SSD-63475709 Tumbi Umbi Retirement Living Project

Please find to follow a response to the further submission received on the Tumbi Umbi Retirement Living Project, including the latest and further submission from Central Coast Council (dated 5 February 2026).

Table 1. Response to Central Coast Council (5 February 2026)

Figure 3-1. Riparian restoration plan

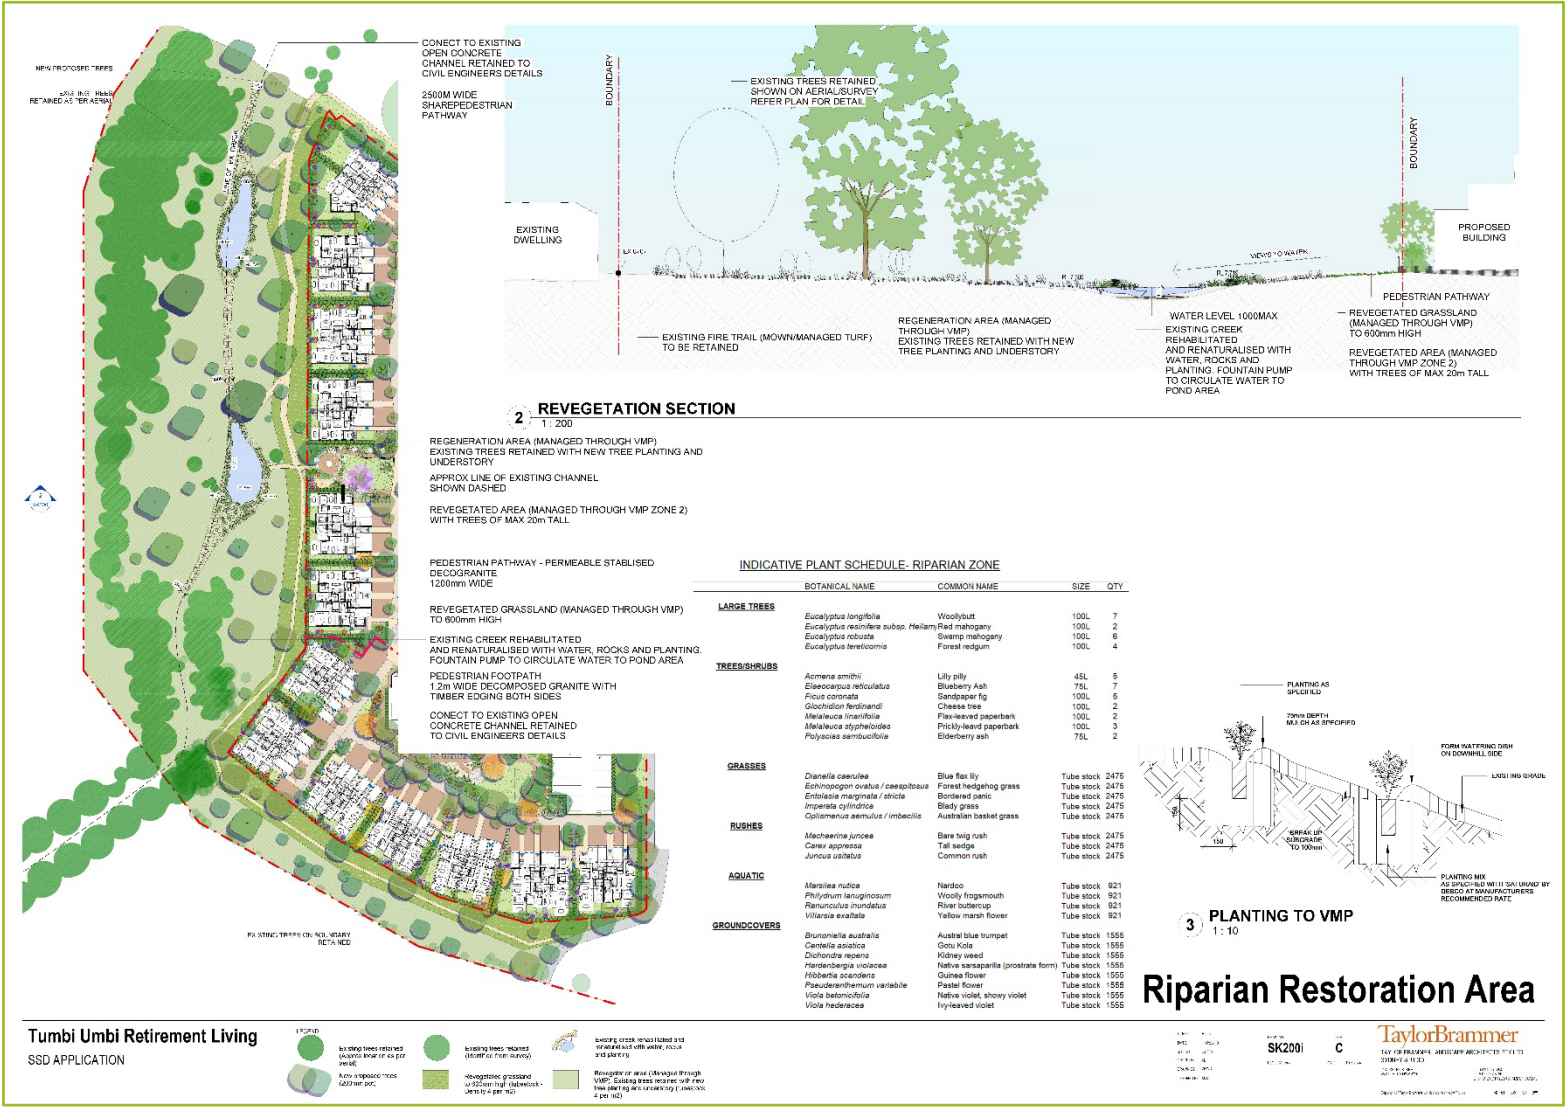
Submission	Response
	+ The riparian restoration area illustrated in the Landscape Plans as shown in Figure 3-1 of the VMP. + The planting schedule in Appendix A that refers to the respective areas show on the Landscape Plans. The canopy trees are being installed as advanced stock, with planting specifications also provided in the proposal's Landscape Plan. Section 4.1 of the VMP specifies the qualifications required for bush regeneration works in Zone 1, which is the following minimum qualifications and experience: + A Certificate III in Conservation and Land Management and/or Certificate III in Natural Area Restoration. + Membership of the Association of Australian Bush Regenerators (or the prerequisite qualifications and experience for membership). + A minimum of 500 hours practical bushland regeneration under an experienced supervisor. The certified and experienced bush regeneration contractor engaged for the project will be sufficiently skilled to undertake the range of weed control techniques specified in Section 4.2.1 of the VMP (which includes: slashing to remove biomass, selective spraying of weeds with herbicides; cutting/scraping and painting deep rooted woody weeds and climbers with hand tools, chainsaws and brush cutters and painting cut stumps with herbicide; and selective hand removal of weeds). It is considered unnecessary to further detail what each method entails. The inclusion of prescriptive weed control methods in VMPs commonly receives negative feedback from the bush regeneration industry. It should also be noted that Zones 2 and 3 must be managed to prevent bushfire hazard and shall be slashed to remove foliage (fuel build up) so that the height of all understorey vegetation (either existing or planted) is

3 PLANTING TO VMP
1 : 10

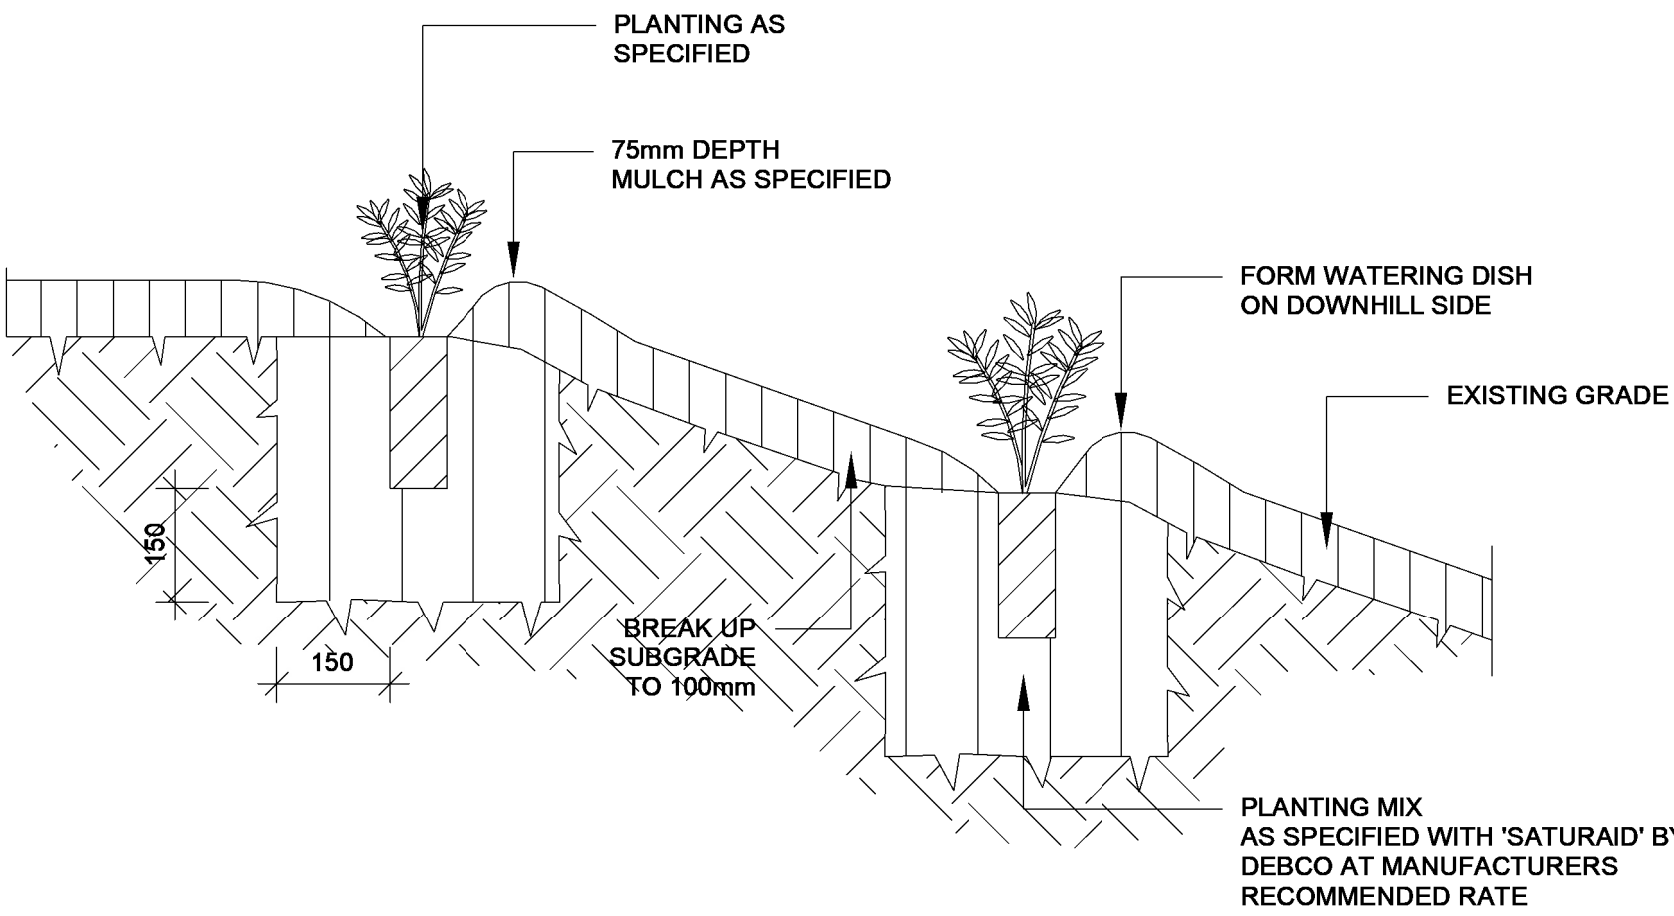
Submission	Response
	■ At intervals of not more than four weeks following the completion of primary weeding ■ All areas where primary weed control has been undertaken ■ All herbaceous weeds should be managed to be at very-low percentage cover levels, (as a minimum 10% cover, or better in Zone 1). + Table 5-1 Defects Liability Period (24 months) ■ Minimum 90% per cent survival rate of each species planted ■ Maximum 5% weed cover in Zone 2 ■ 100% of Zones 2 and 3 maintained by slashing (and guidance provided as to frequency required to maintain at 100mm height). The above performance measures cover 30 months after which time maintenance in perpetuity commences. At this time performance measures would be guided by the handover reporting as specified in Table 4-1 of the VMP.
+ The VMP offers insufficient detail on local provenance planting, planting densities and weed management, and	VMP Section 4.5.1 identifies that sufficient lead time is required to enable locally sourced plant stock, and that: + Plant procurement shall either be undertaken by the Principal or the Contractor (to be determined on engagement of Contractor). + Most commercial nurseries that supply native plant stock have the capacity to provide suitable seed or other propagative materials (from provenance source) without the need for targeted collection of seed/ propagation materials. Planting densities and stock size are specified in the planting schedule and site plans provided in the proposal's Landscape Plan. The VMP Appendix A has been updated to show the indicative riparian area's landscape planting schedule. Noting that the VMP has referenced both the following:
